**HORSLEY DRIVE BUSINESS PARK –
Response from Western Sydney Parklands Trust dated 12-September 2012**

COMMENTS ON HORSLEY DRIVE BUSINESS PARK – COSTIN ROE
CONSULTING CIVIL ENGINEERING REPORT BY CATCHMENT MANAGEMENT
BRANCH (18 SEPTEMBER 2012)

BREAKLINE - FOR CONTINUATION REFER TO DRAWING DA41-4

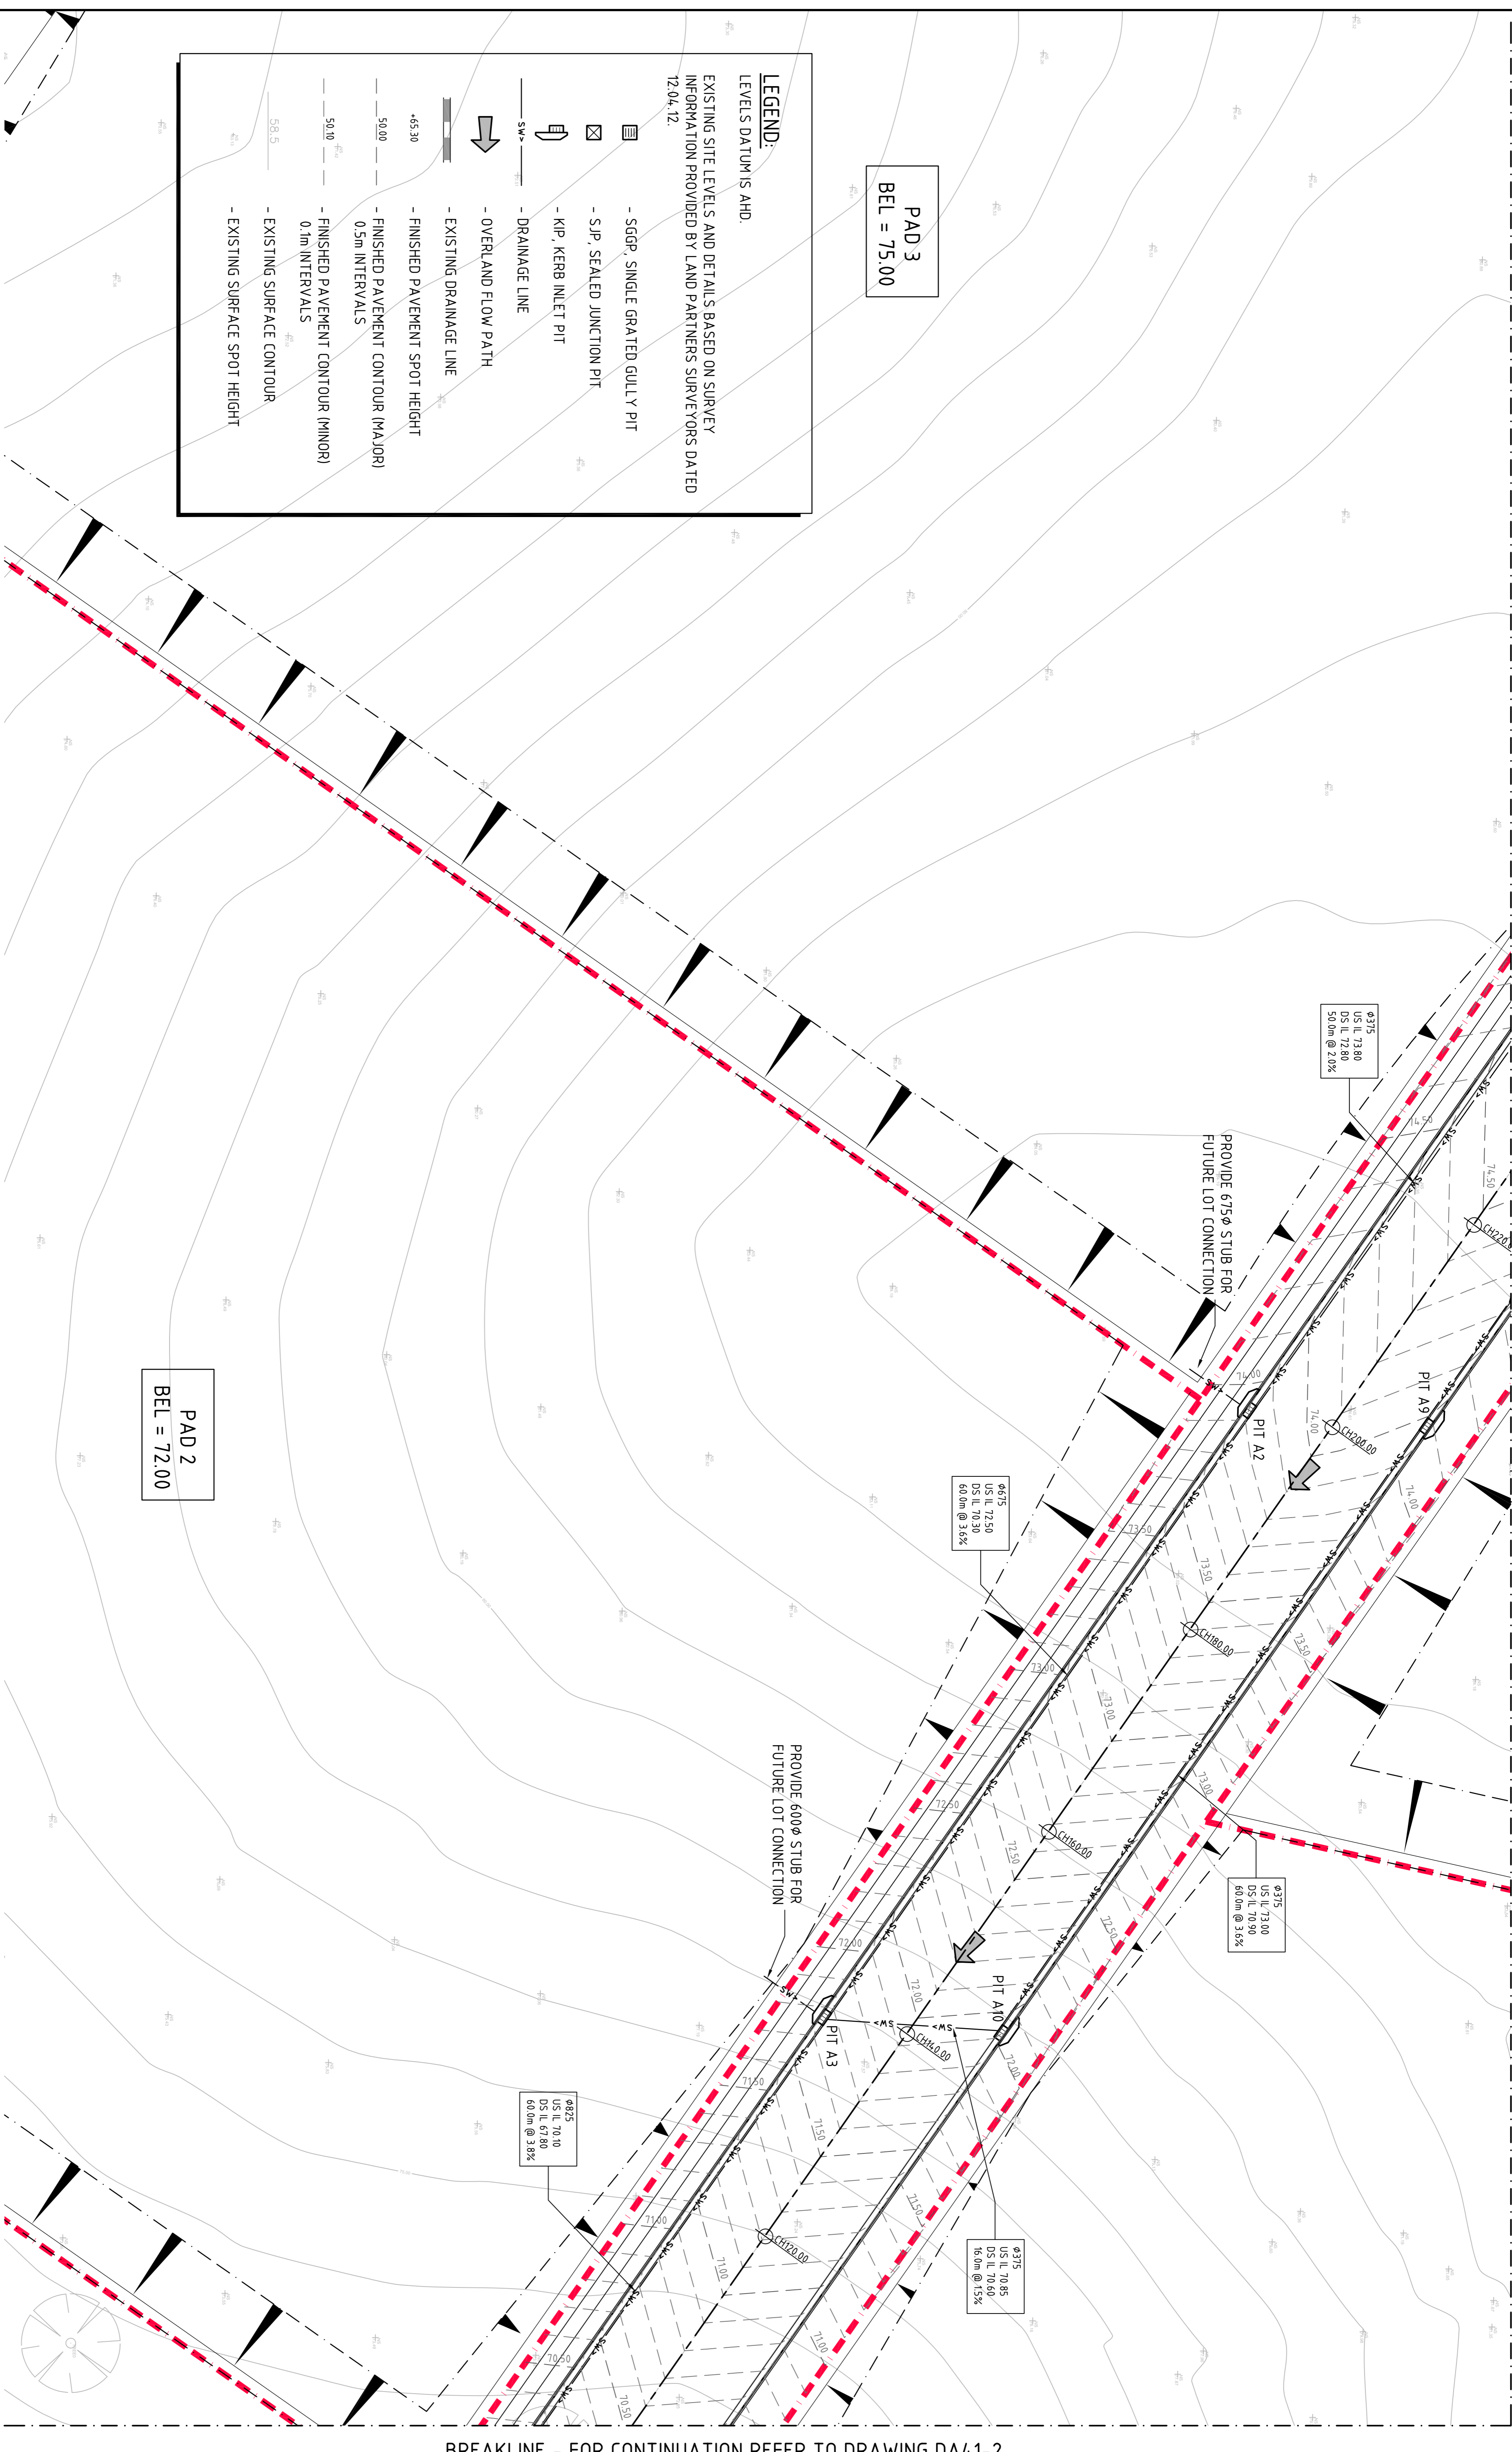
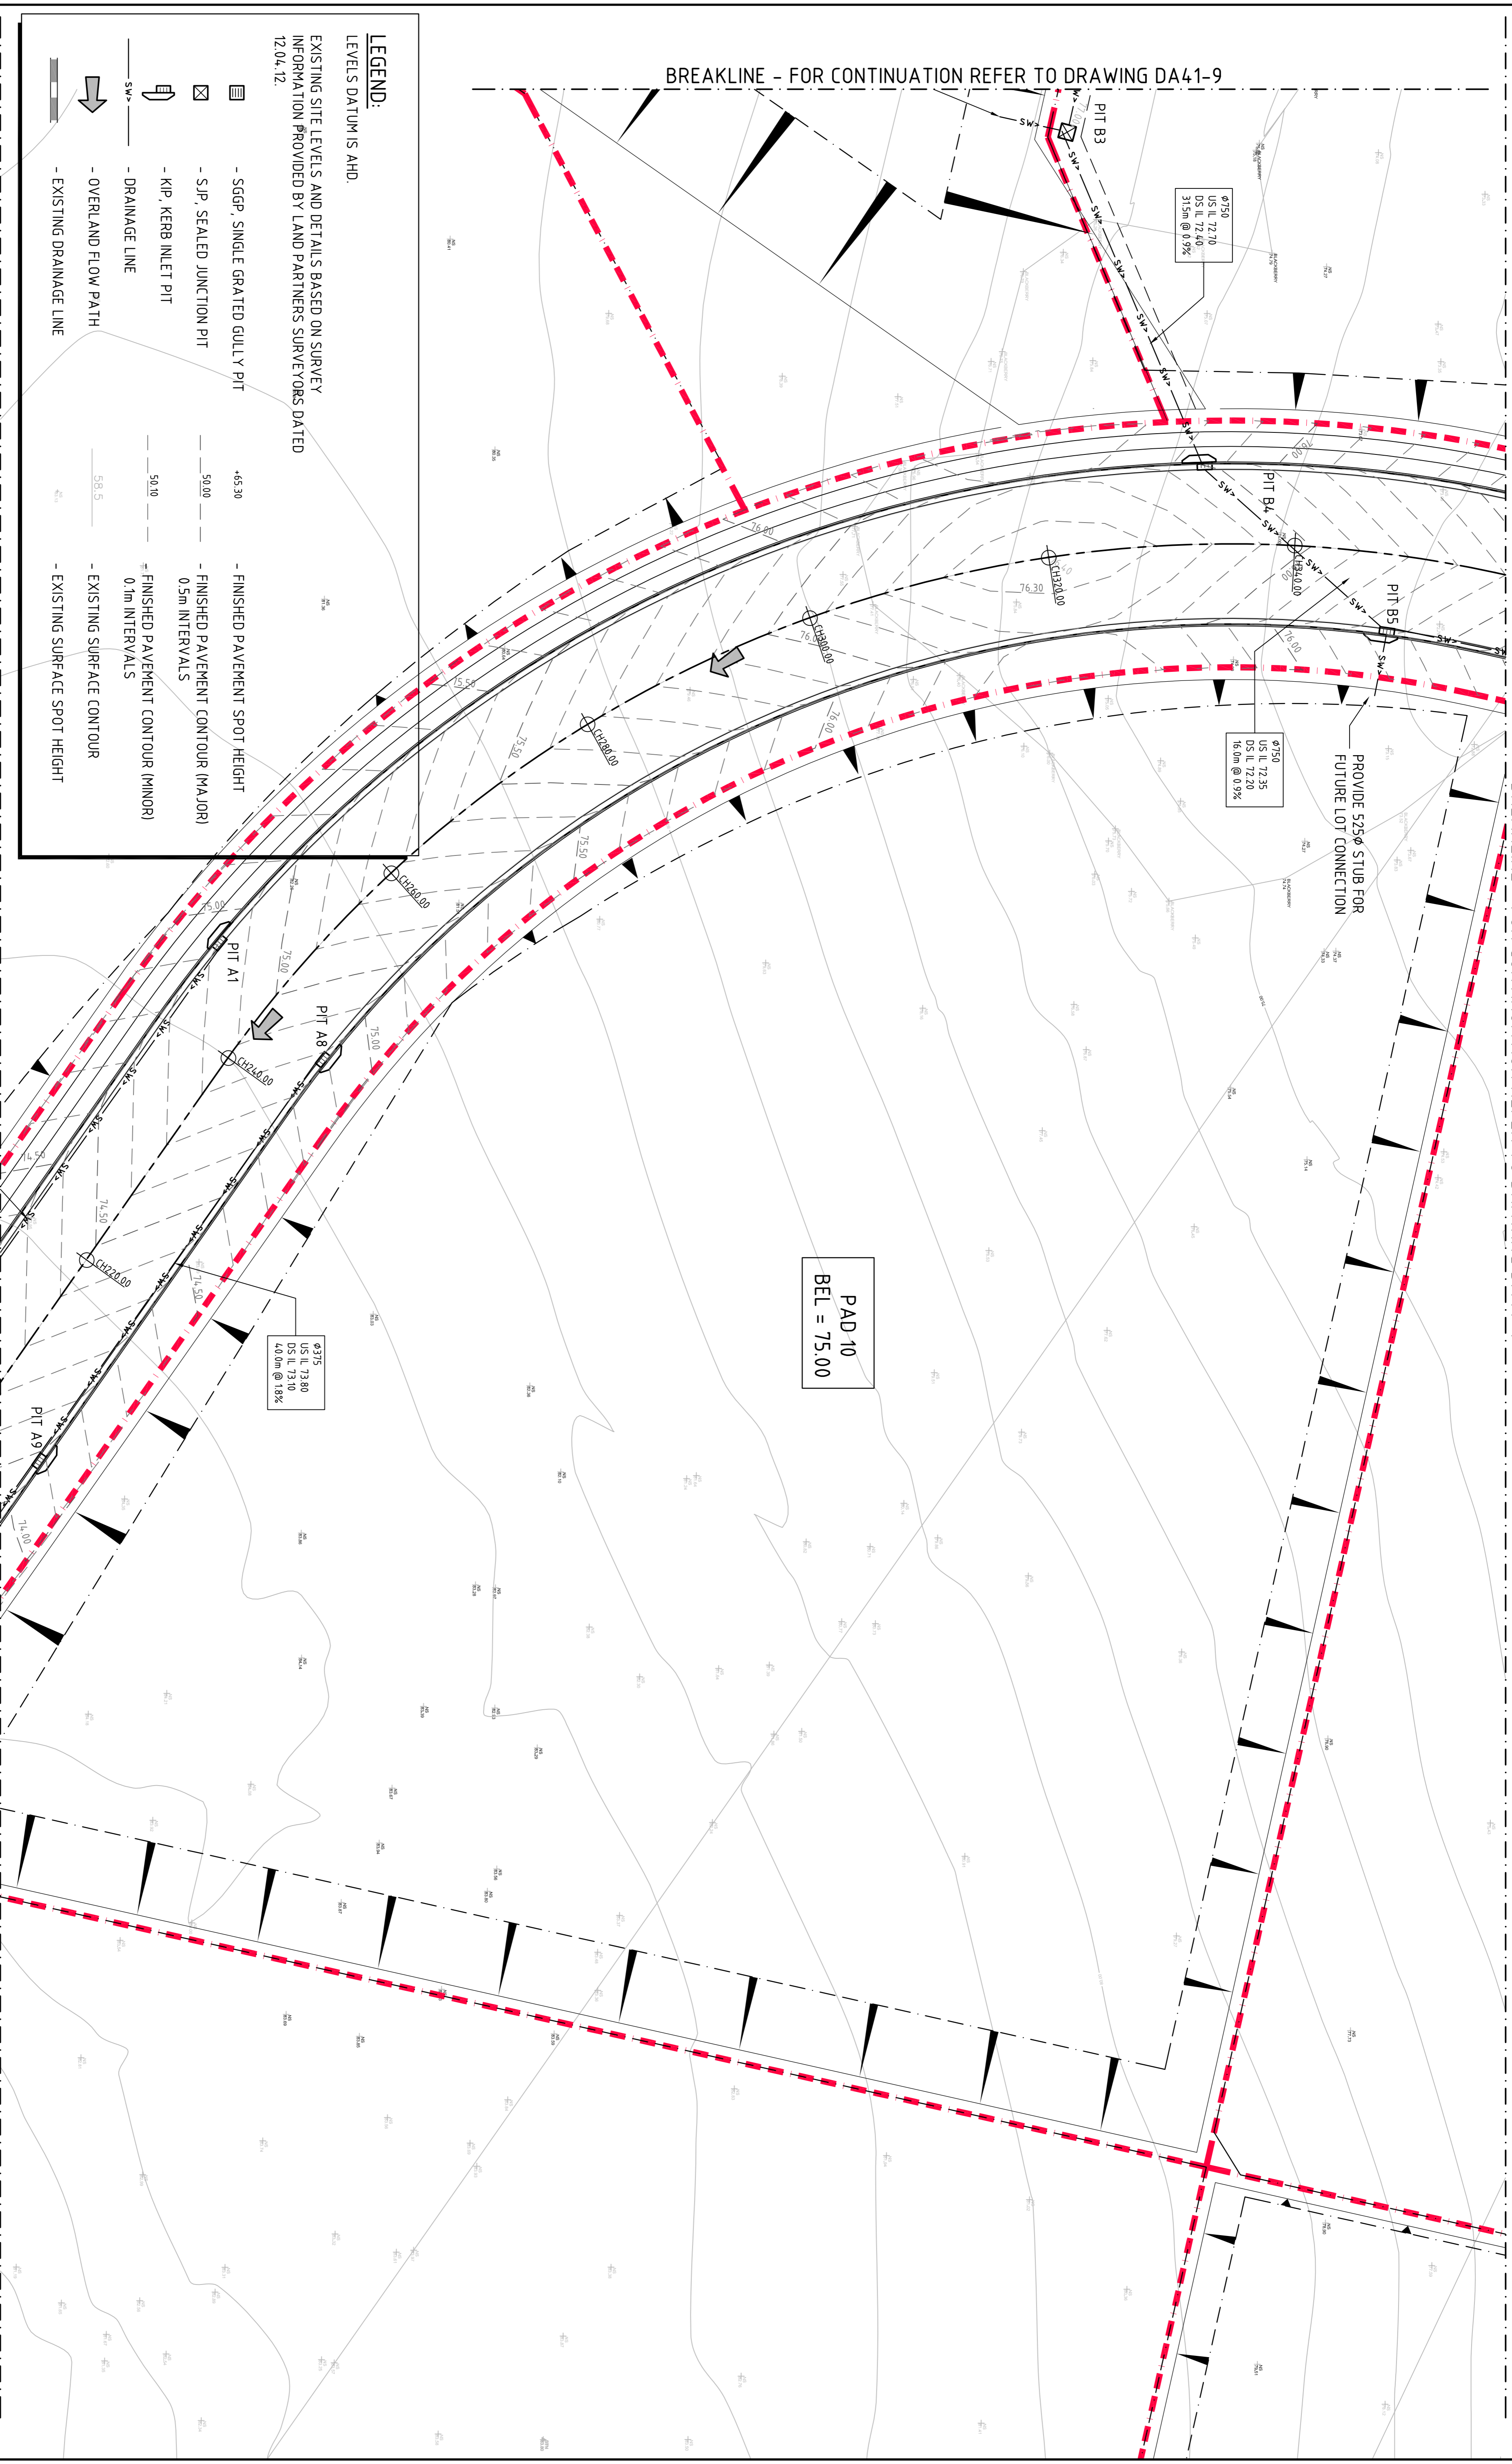
5.4	14	Need to ensure that there is sufficient grade on the overland channel around northern extent of the development. Please provide calculations undertaken to ensure the channel is sufficient.

5.6	16	Details need to be provided with respect to the outlet configuration of both of the basins to ensure they are in compliance with Councils OSD policy requirements.
5.6	16	Do the calculations for OSD include the western undeveloped catchments, as per modelling of flooding at the intersection of Cowpasture Road and Victoria Street.
